**Consultation Response from KC,
Lead Local Flood Authority**

2023/91212 Land off, Bankfield Drive, Holmbridge, Holmfirth, HD9 2PH

Erection of 21 dwellings with access from Laithe Avenue

Date Responded: 01/11/2023.

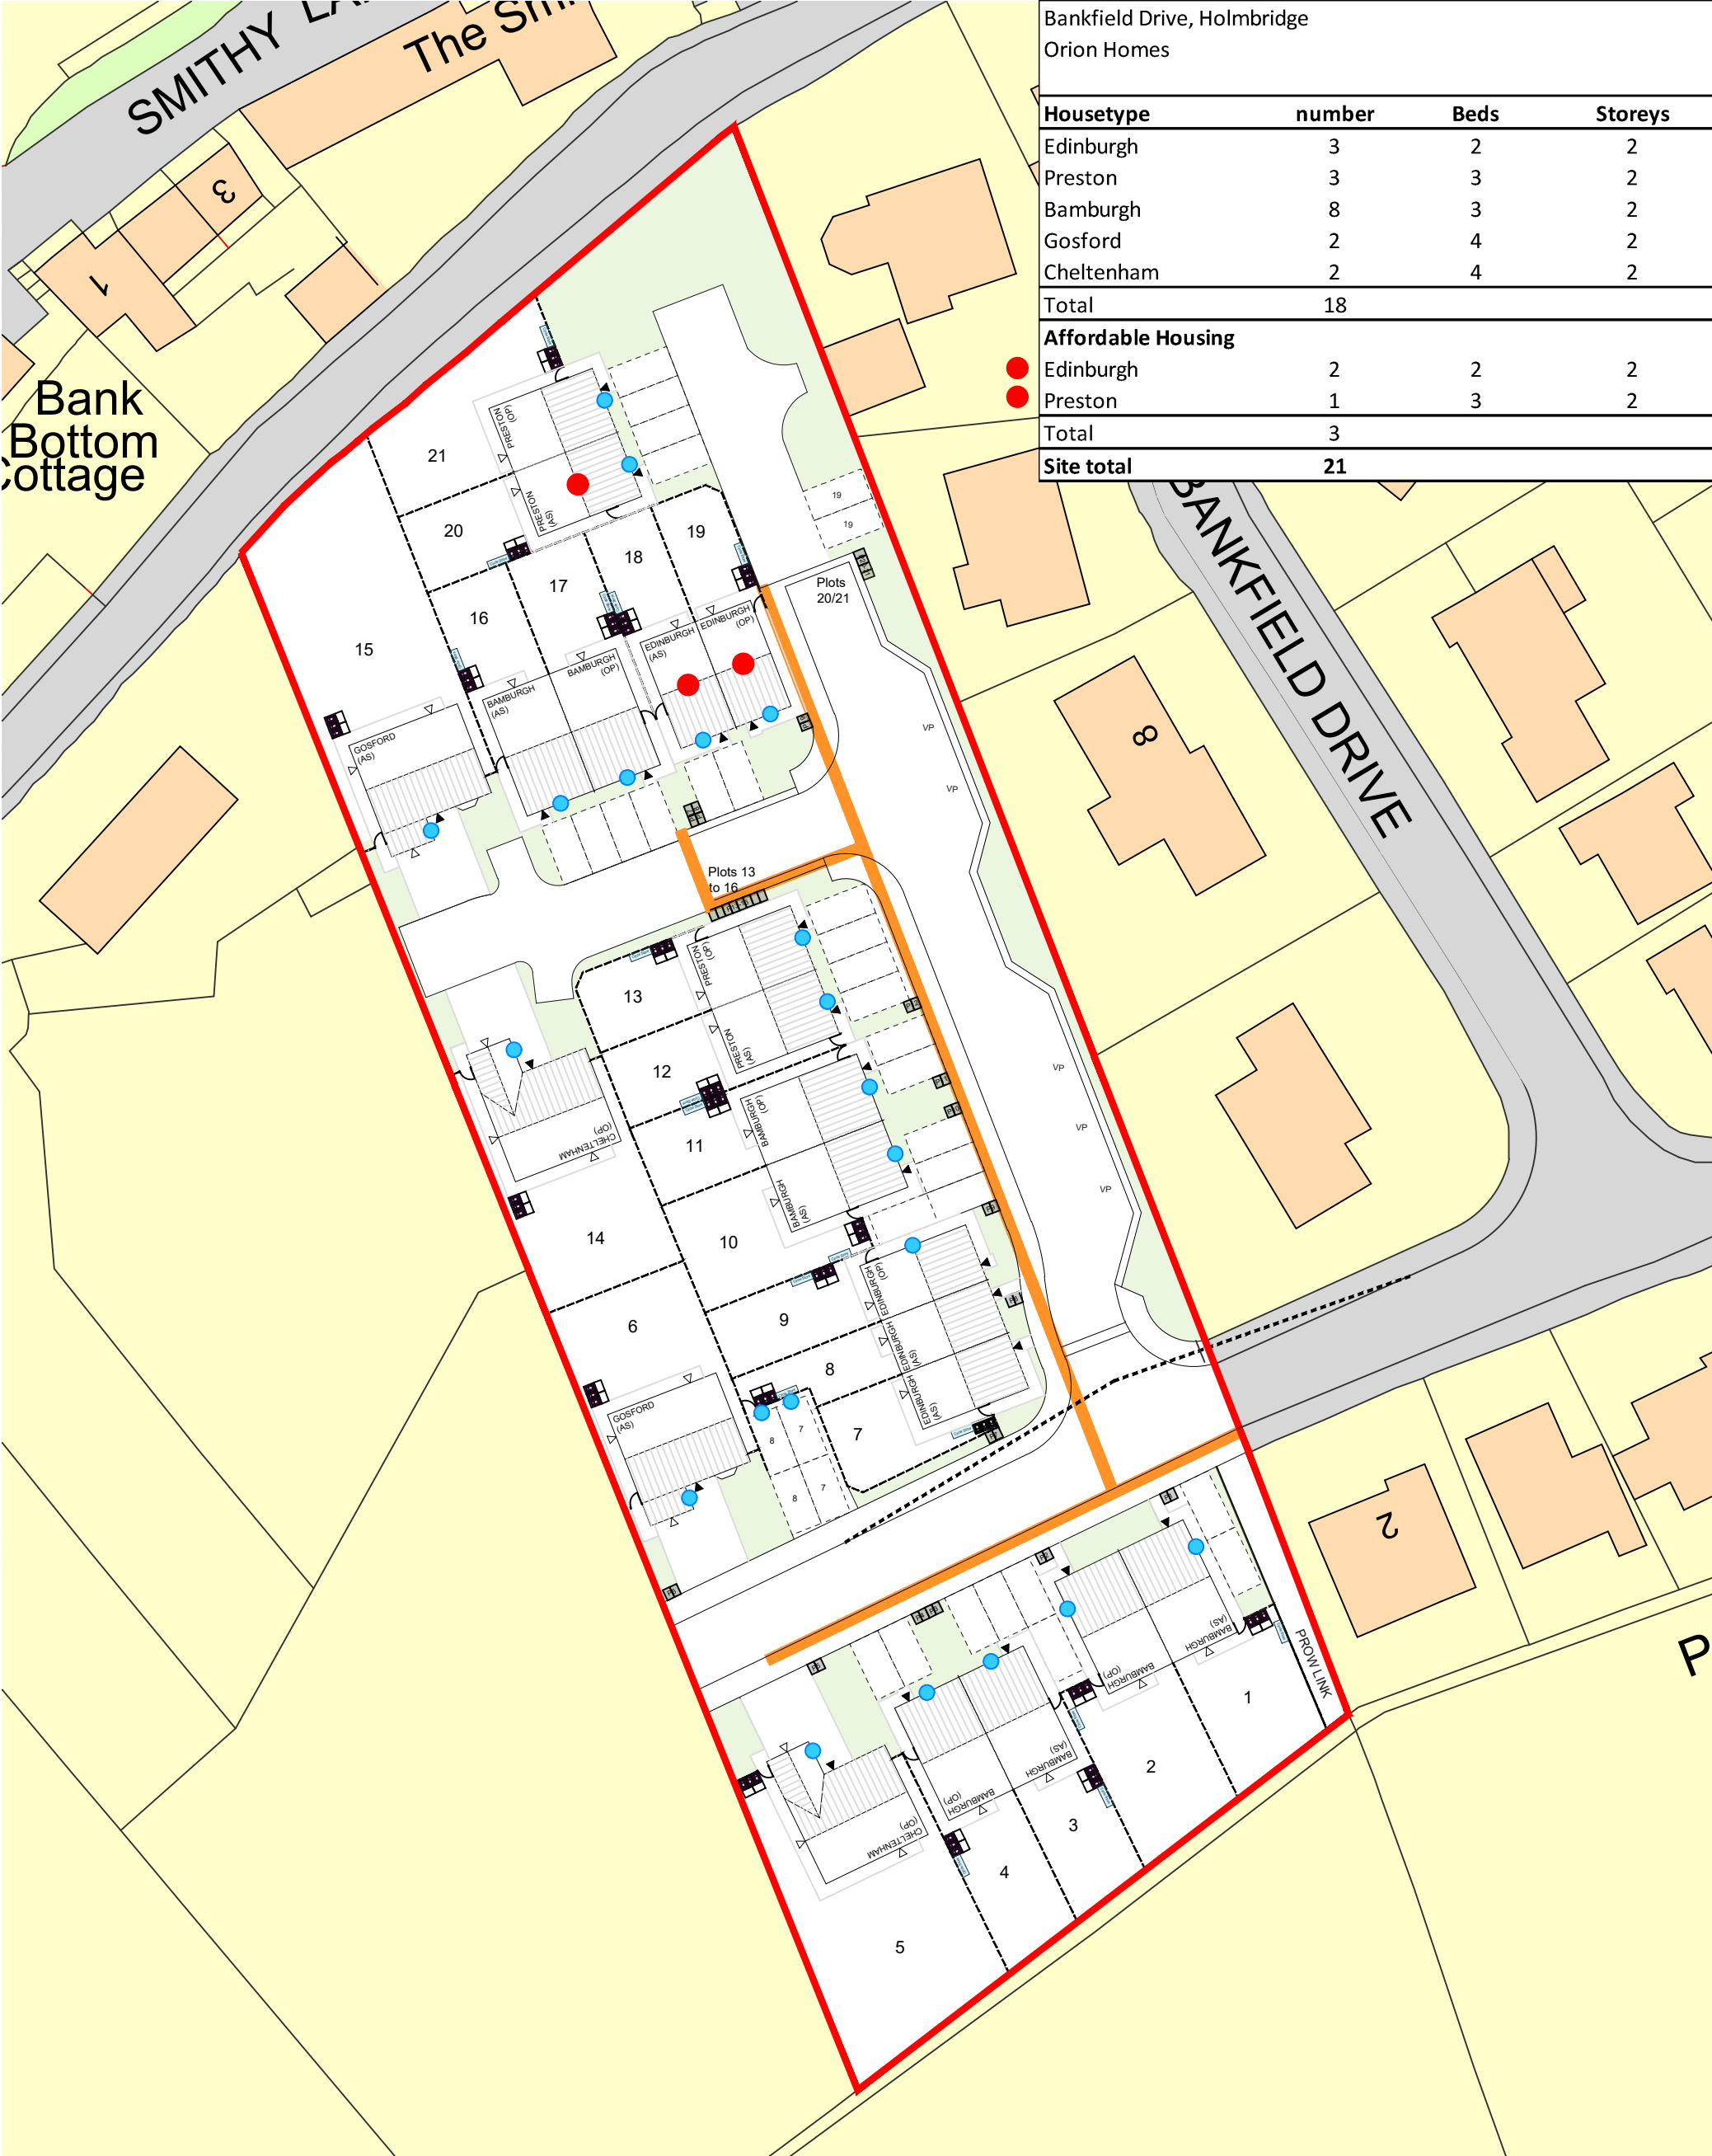
The submitted plan does not show any drainage details and no other drainage related information has been submitted since the previous LLFA consultation.

The developer will therefore need to submit drainage drawings, details, calculations, etc. based on an allowable surface water discharge rate limited to the equivalent greenfield run-off rate of **5.0 l/s per ha** of impermeable drained area (subject to a minimum flow control outlet of 75mm).

Kirklees Flood Management and Drainage as Lead Local Flood Authority, OBJECTS to this planning application and requires that a revised surface water drainage strategy is submitted taking into account the reduced allowable discharge rate as stated in the previous LLFA response and FURTHER INFORMATION is provided as noted above.
